HWY 105/Jackson Creek Pkwy
Town of Monument

RE: CDR HWY 105/JCP Construction Drawing Review

The State Highway 105/Jackson Creek Parkway - Phase 2 Construction Plans dated February 2023 revised 5/11/2023 have been reviewed by the CDOT North Program Traffic Manager. Their comments are as follows:

V:\130222\ROADWAYS\CONSTRUCTION\DRAWINGS\17-STRIPING-01.dwg, 7/20/2023 10:38:39 AM, Whorton, 1:1

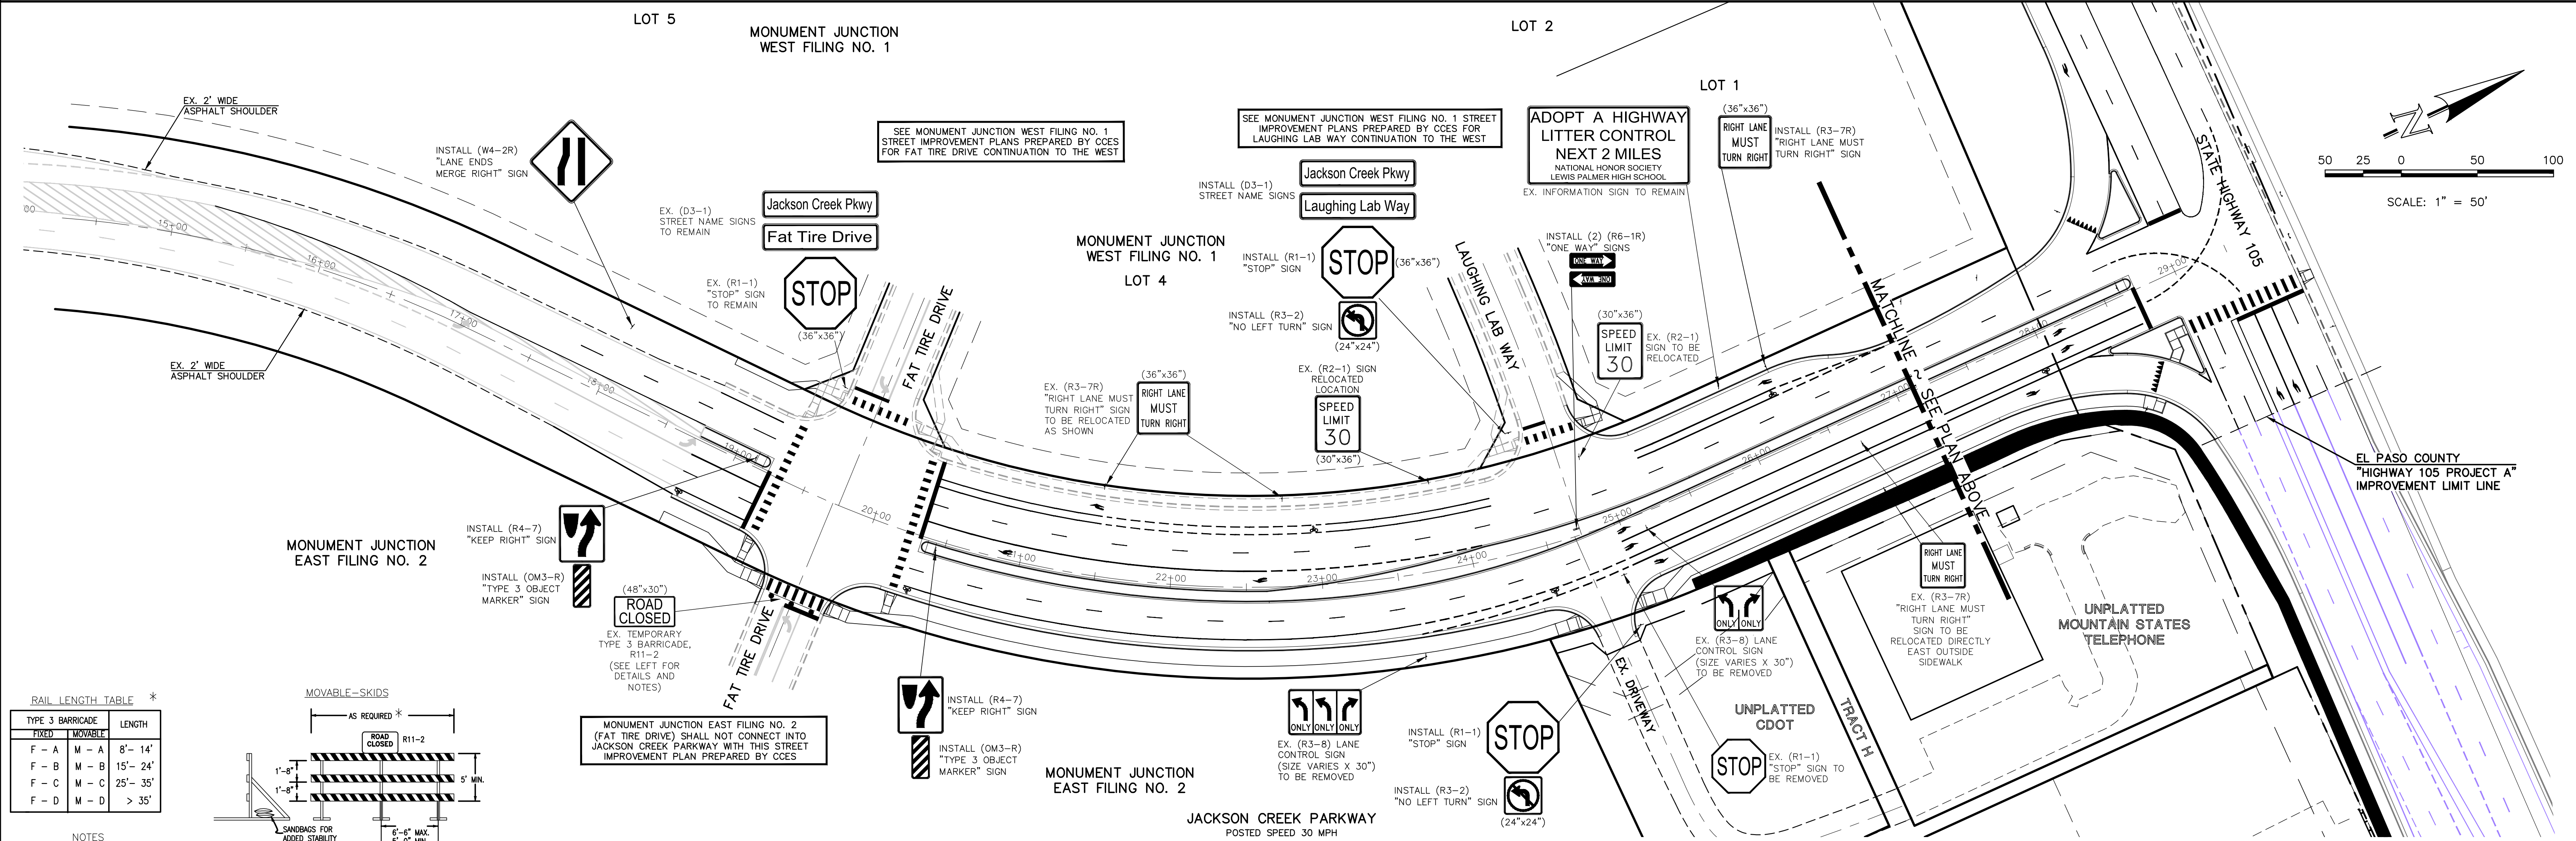
- Sheet 17 - The "dotted" marking is 2' segment with 4' gap. Add two arrow in the WB to SB left turn lane at the I-25 Ramp.
- Sheet 18 - Are the TRUCKS over 26k signs still appropriate?
